Rezoning Transportation Analysis

Petition Number: 2022-116

Revision Log:

Date	Description
12-28-22	First Review (IW)
1-9-2023	Second Review (DR)
11-27-2023	Third Review (NK)
11-30-2023	Trip Generation Update

# RZ-2

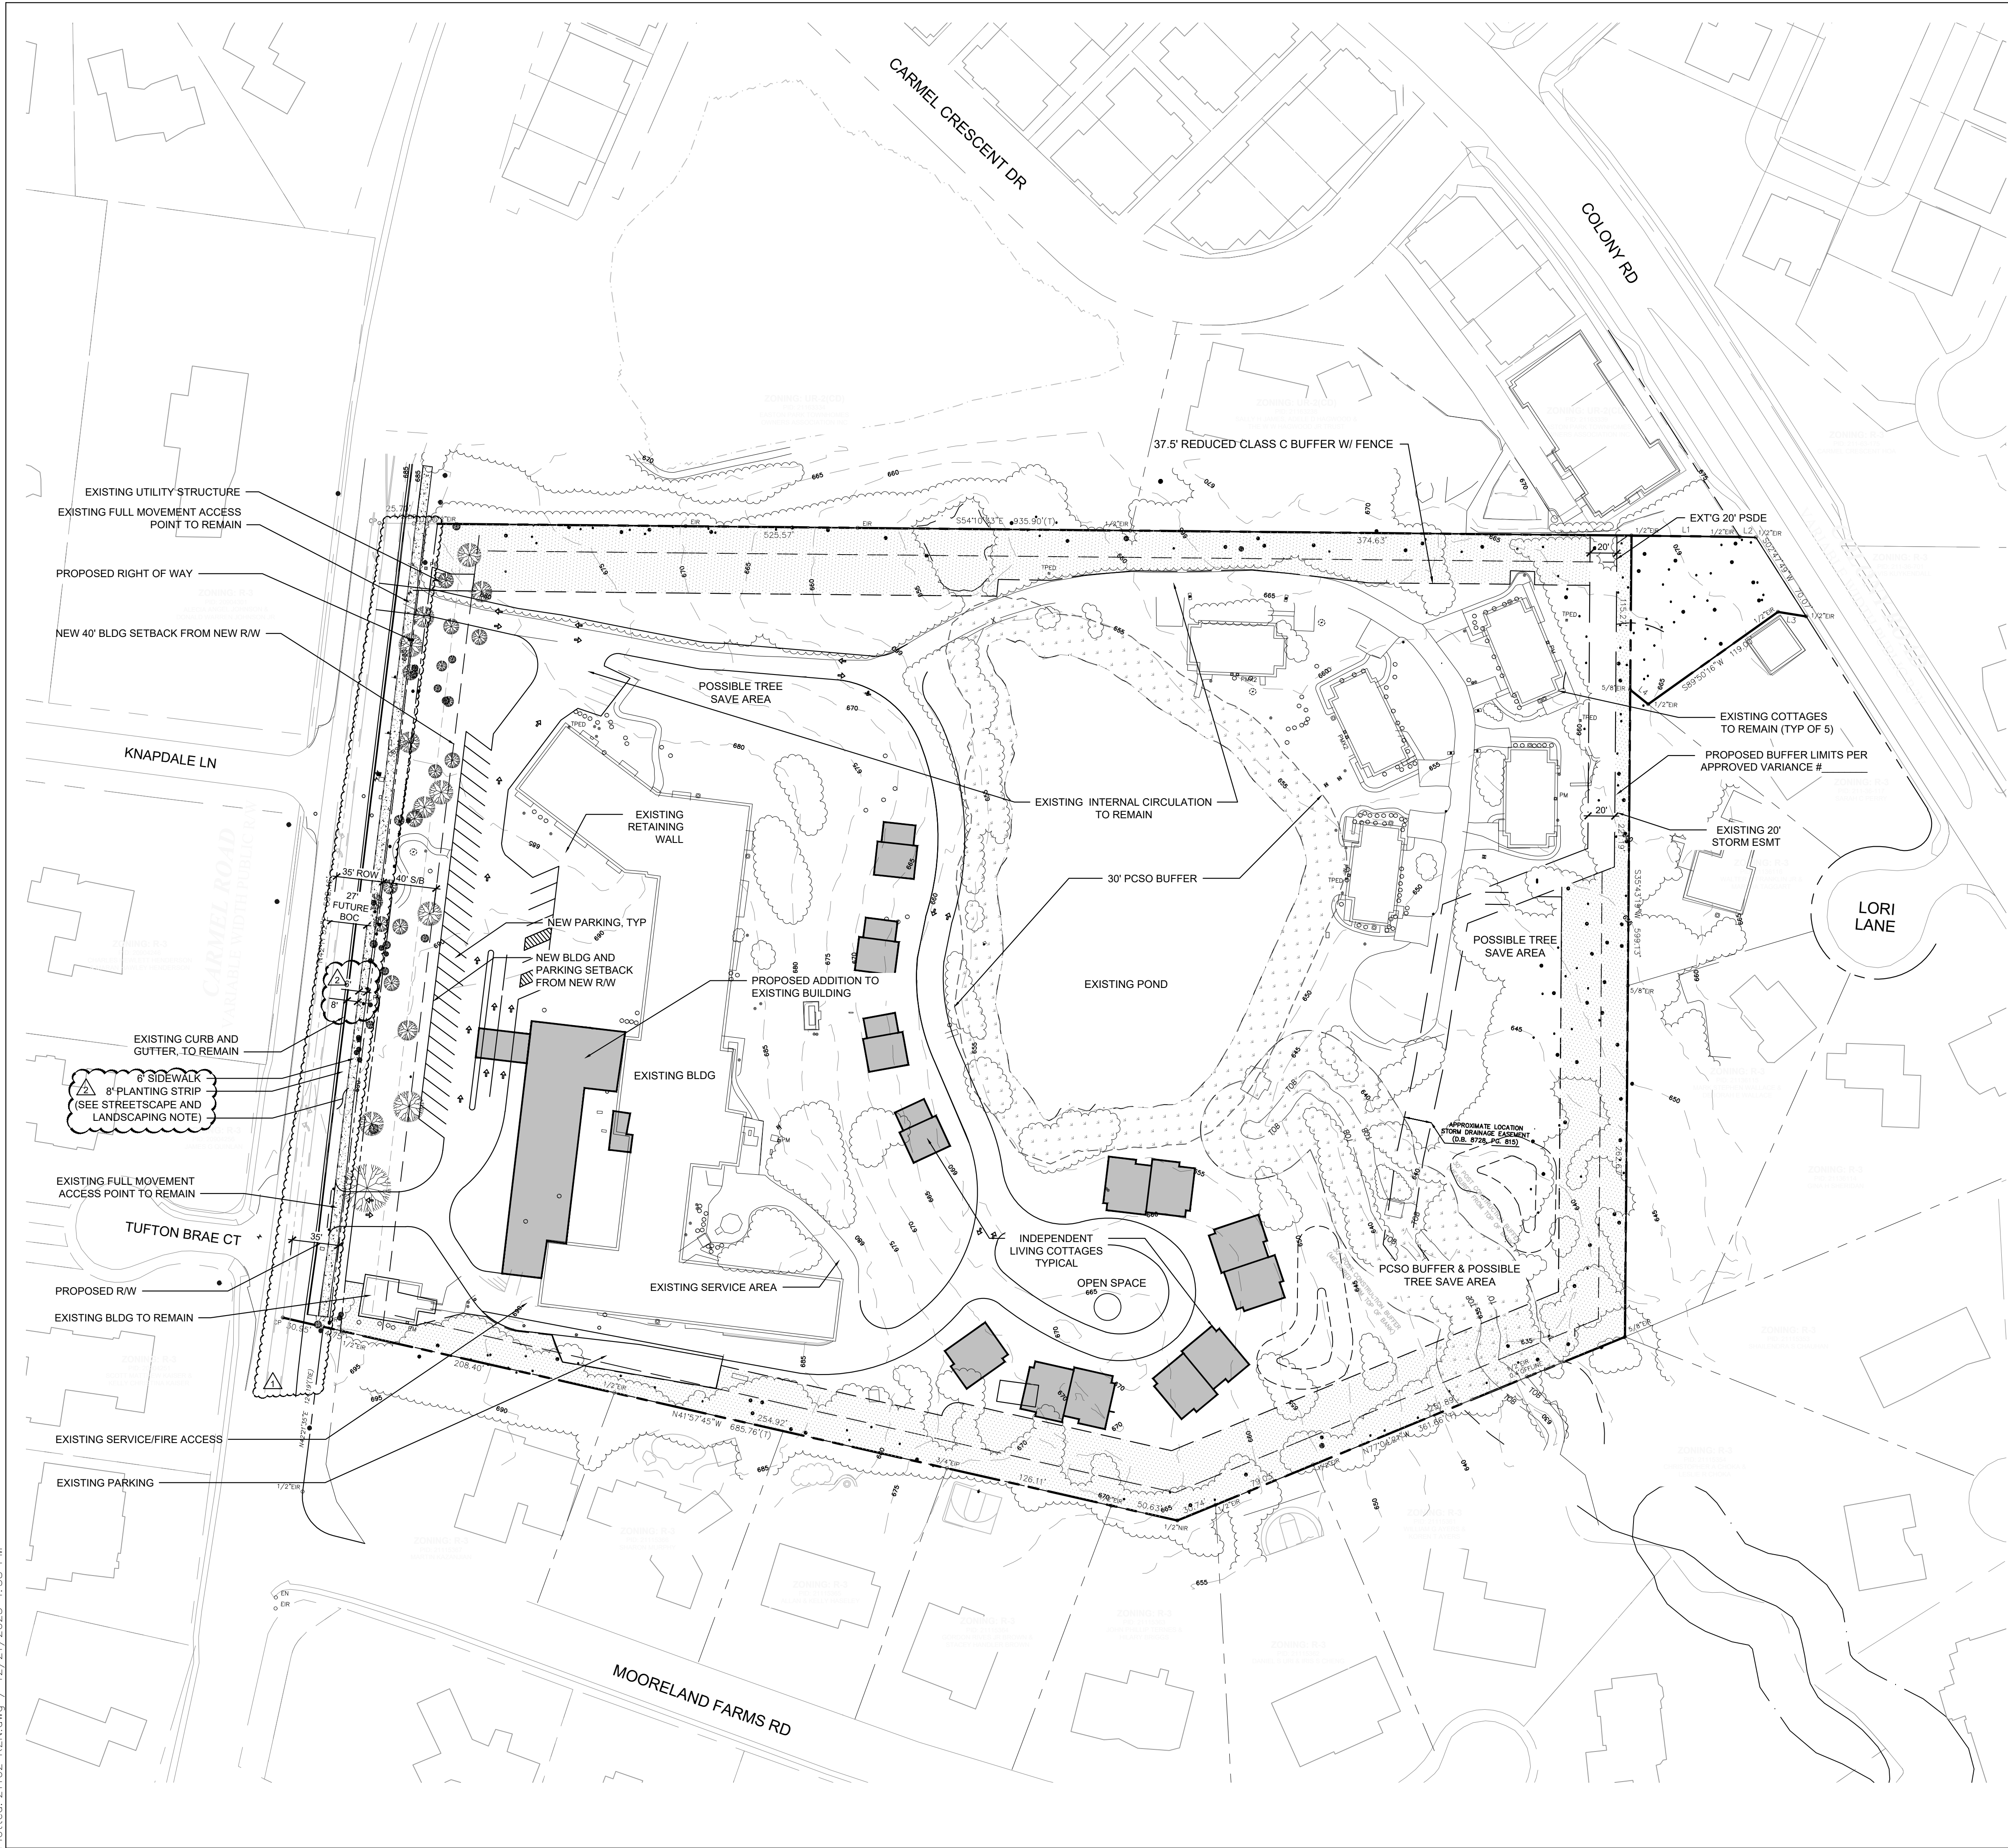
Label and dimension the curb and gutter from the centerline for each road on the site plan.

- 3. Revise site plan and conditional note(s) to commit to dedicate 43 feet of right-of-way from the Carmel road centerline. The site plan shall label and dimension the right-of-way from the road centerline.

Additional Comment 11/27/23 – Carmel Road needs to be labeled and include that it's a public road.

Per Chapter 19 revise site plan and conditional note(s) to commit to construct an 8-foot planting strip, and 6-foot sidewalk on Carmel Road.

Clarifying Comment 11/27/23 – According to Chapter 19, there needs to be an 8-foot planting strip instead of the sidewalk located at the BOC as shown along Carmel Road and Colony Road.

4. Request to revise site plan and conditional note(s) to commit to construct a buffered bicycle facility along Carmel Road by locating the back of curb and gutter 27' from the center line to meet the Council-adopted Charlotte BIKES Policy.

8. Add a conditional note specifying "All transportation improvements will be approved and constructed before the site's first building certificate of occupancy is issued. The petitioner may phase transportation improvements if said improvements and phasing are explicitly described in site plan notes."
